Submission - Lane Cove West Data Centre - SSD-9741

I am a resident of Lane Cove and a long-standing member of Lane Cove Council's Bushland Management Advisory Committee. While I do not object to the location of a data centre in this area, per se, as it seems a land use compatible with the surrounding area, this proposal is unsuitable for this site and I would like to register objections to the existing proposal on several important grounds:

SULE Assessment Plan

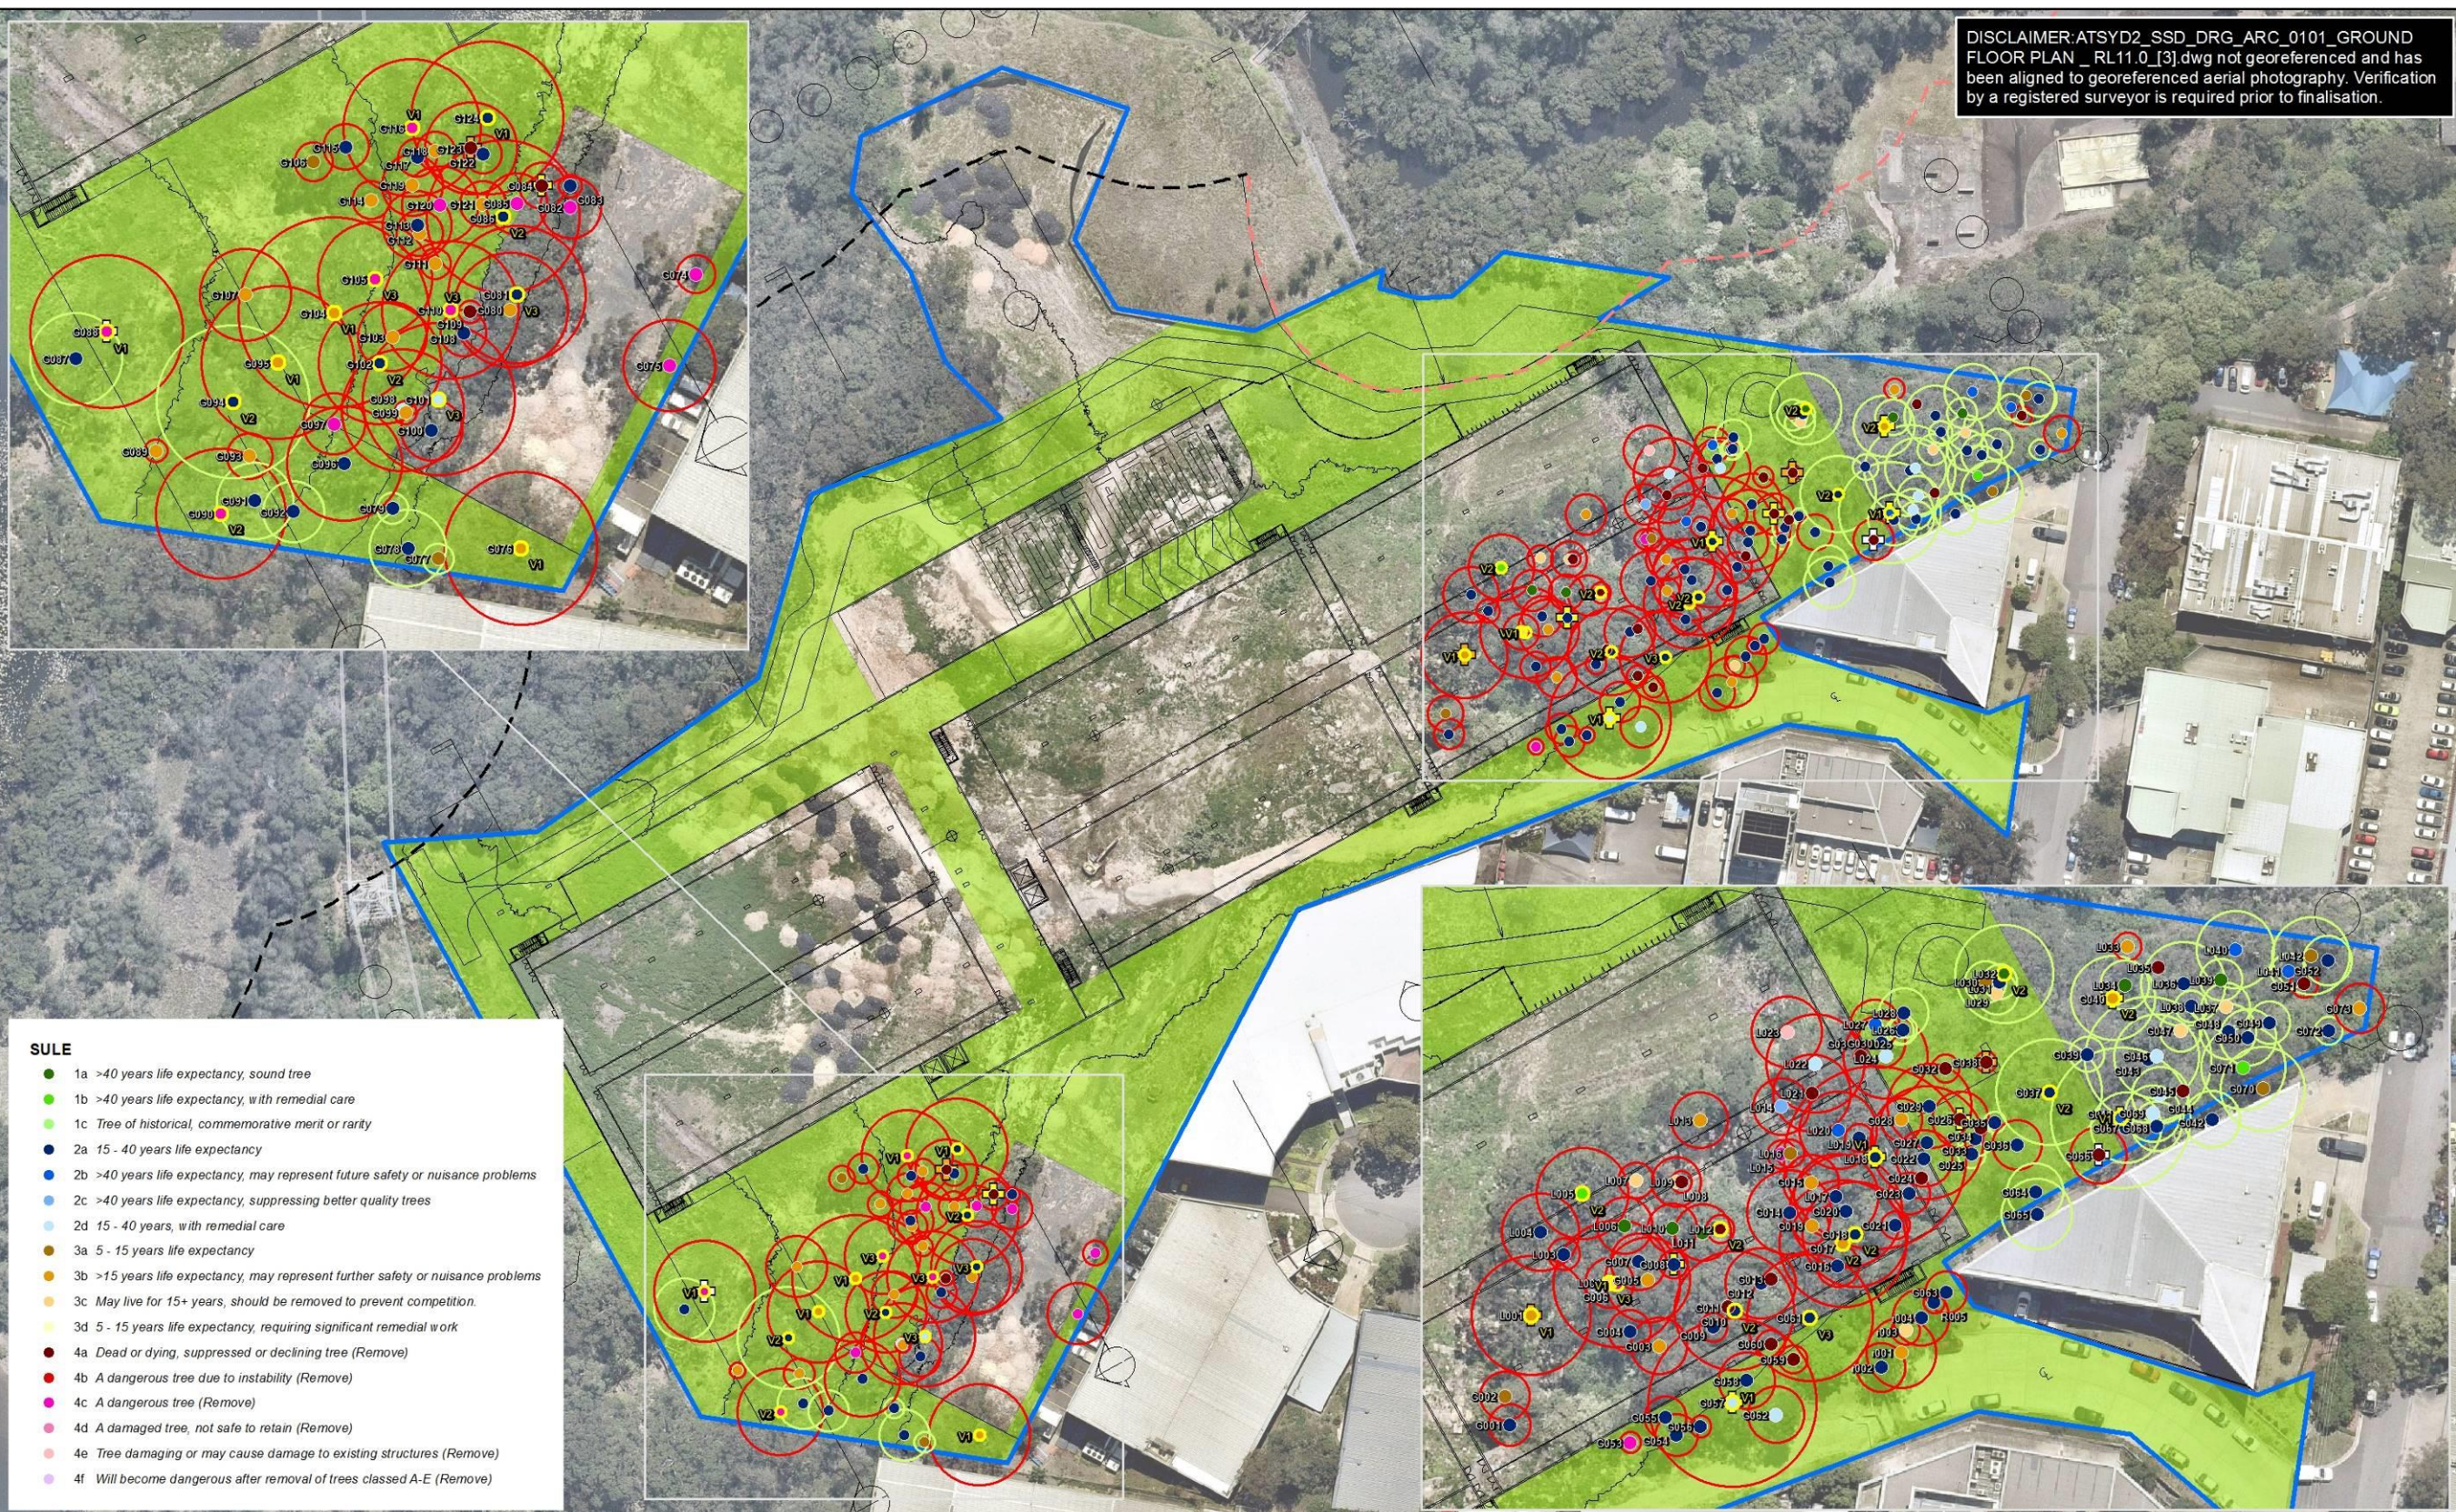
Most of the vegetation on this site will be impacted through complete clearing for the buildings or by heavy management in a bushfire Asset Protection Zone. For example, here are currently 171 trees (with diameter 15cm or above) currently on this site. This development will remove:

- 82 trees in fair to good condition (SULE 2d or above), in addition to the 43 to be removed as they are assessed to be in poor condition.
- 24 of 29 visually significant trees
- 10 of 12 hollow-bearing trees

For Lane Cove this is an unacceptable level of loss. While these removals/clearing of native vegetation trigger offset purchases, purchasing offsets which may be within 100km of the development site is totally inadequate. In inner urban Lane Cove, loss of any remnant of native vegetation is serious as there is so little and all remnants are highly valuable as both historical records and in the provision of networked habitats and corridors.
